**Sikh Grammar School Rouse Hill (SSD-9472)
Response to Submissions**

ATTACHMENT 1

TREE CANOPY COVER - EXISTING

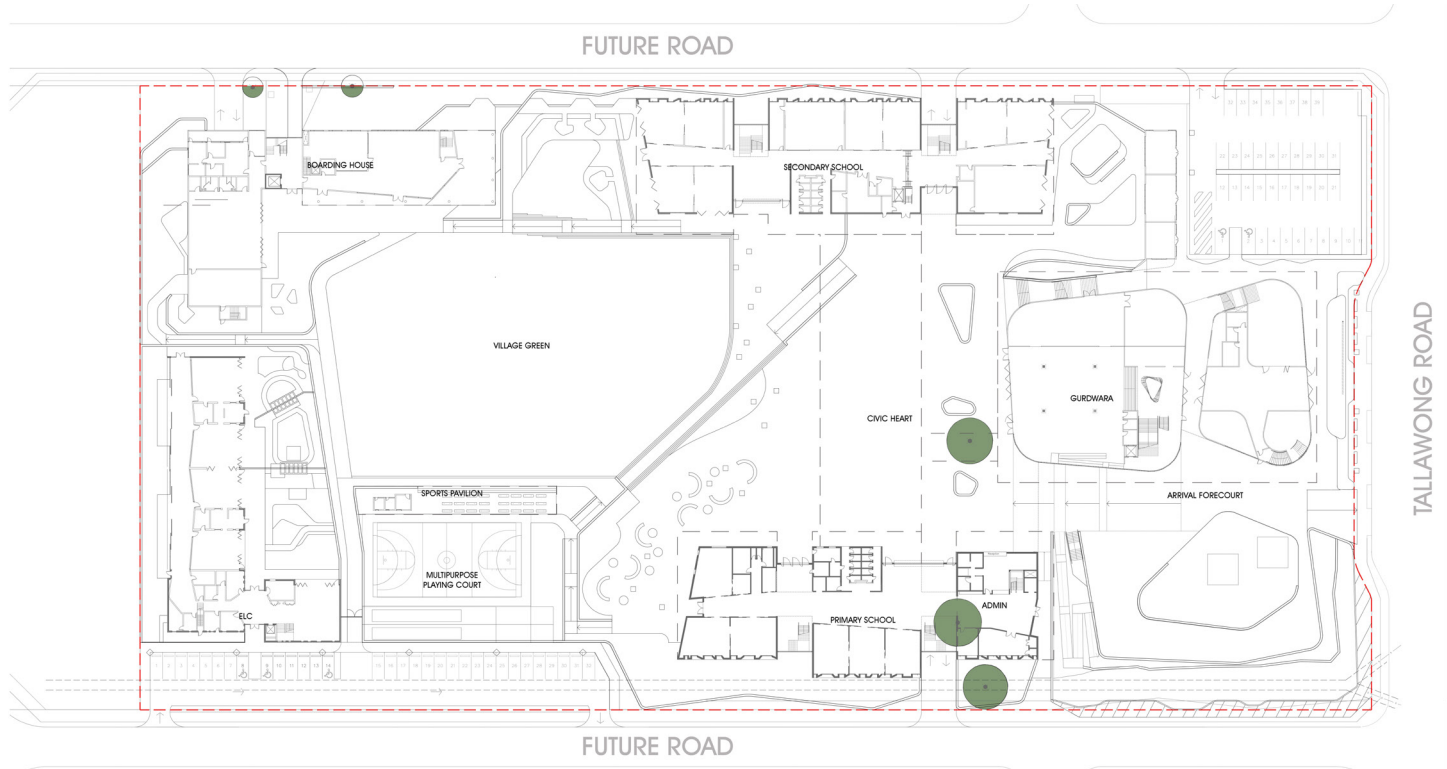
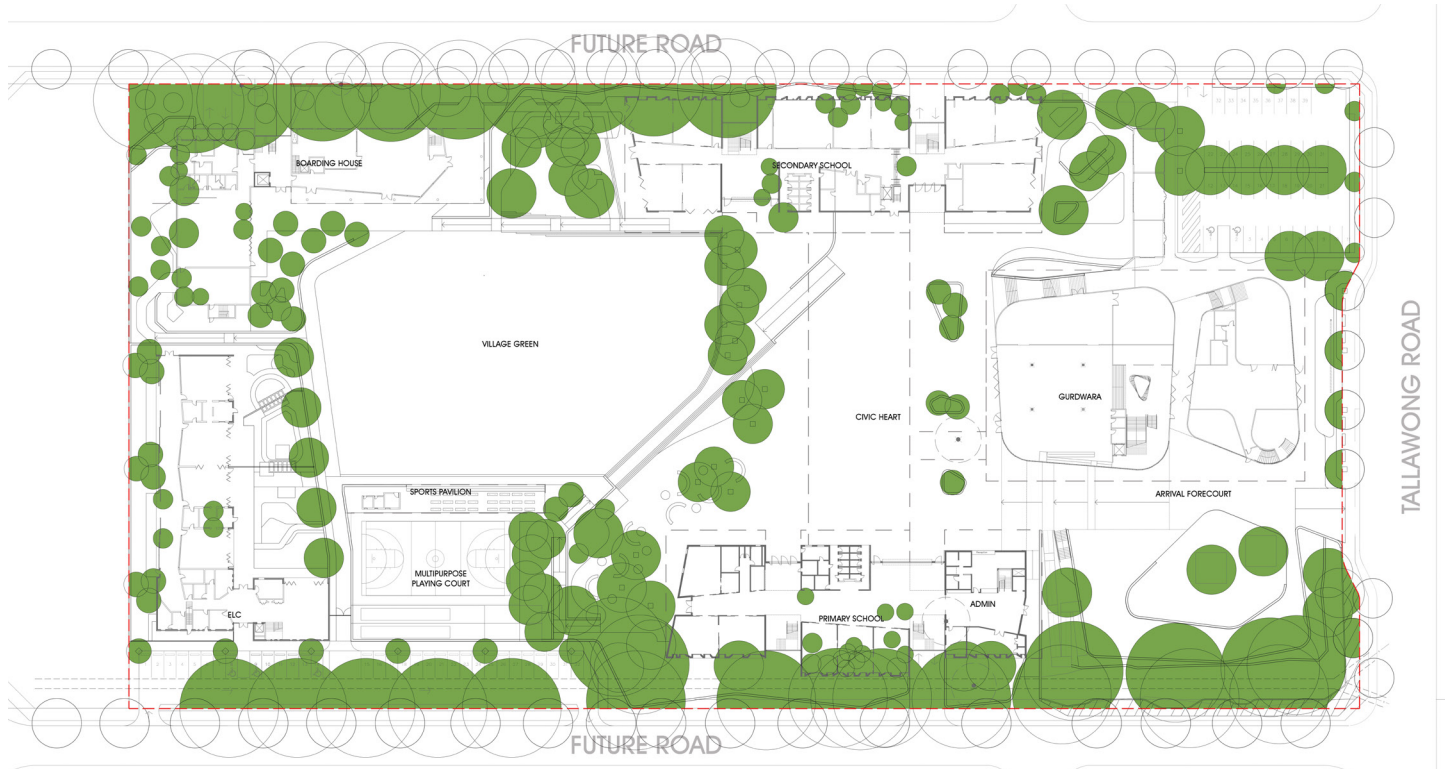
- The landscape schedule within the submitted landscape plan is to be revised to include the total number of trees proposed to be planted and removed.
- The Department is concerned regarding respect to the heat island effect resulting from the proposed artificial lawn on the village green and paved concrete areas in particular at 'civic heart'. The Department recommends reducing the heat island effect through replacing artificial lawn with real lawn, increasing the amount of soft landscaping and planting (including canopy cover) around the civic space, outdoor play areas and car parks, to provide more external shading. An assessment is to be provided which considers the heat island effect having regard to the proposed treatments and which demonstrates that the proposal would provide a safe and comfortable environment for staff, students and other visitors to the site.

Figure A: Marked up Detail Survey showing tree locations and numbering.

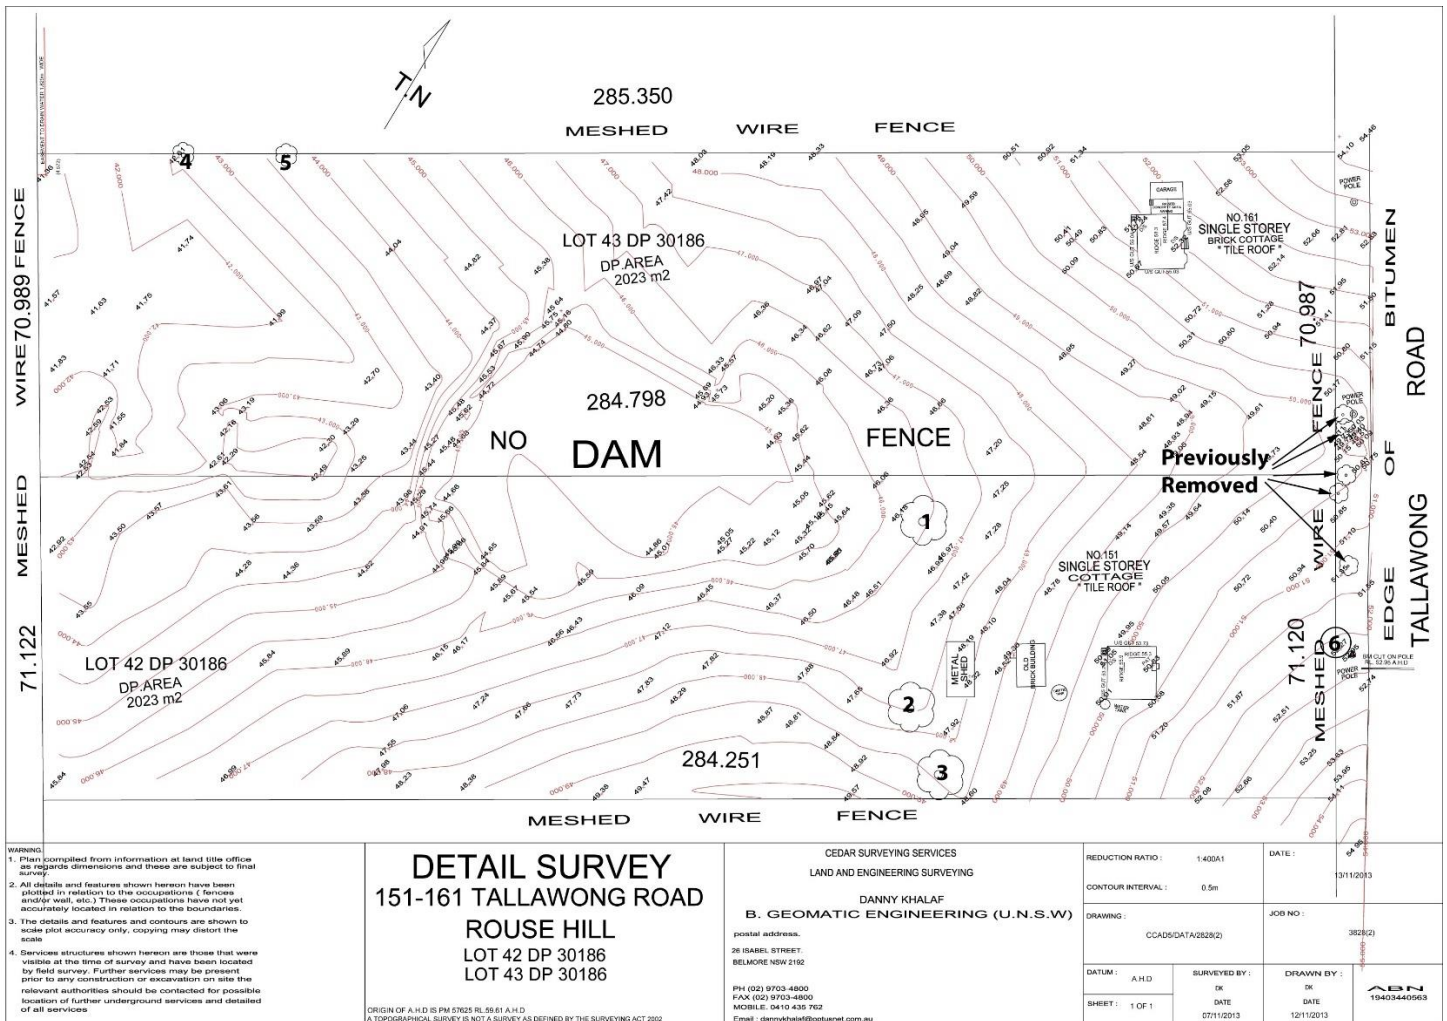
- The proposal impacts existing trees on the site. An Aboricultural Impact Assessment report is to be prepared by a suitably qualified person that details of all the existing trees on site, the impact to these trees and provides justification for the removal of trees where required.
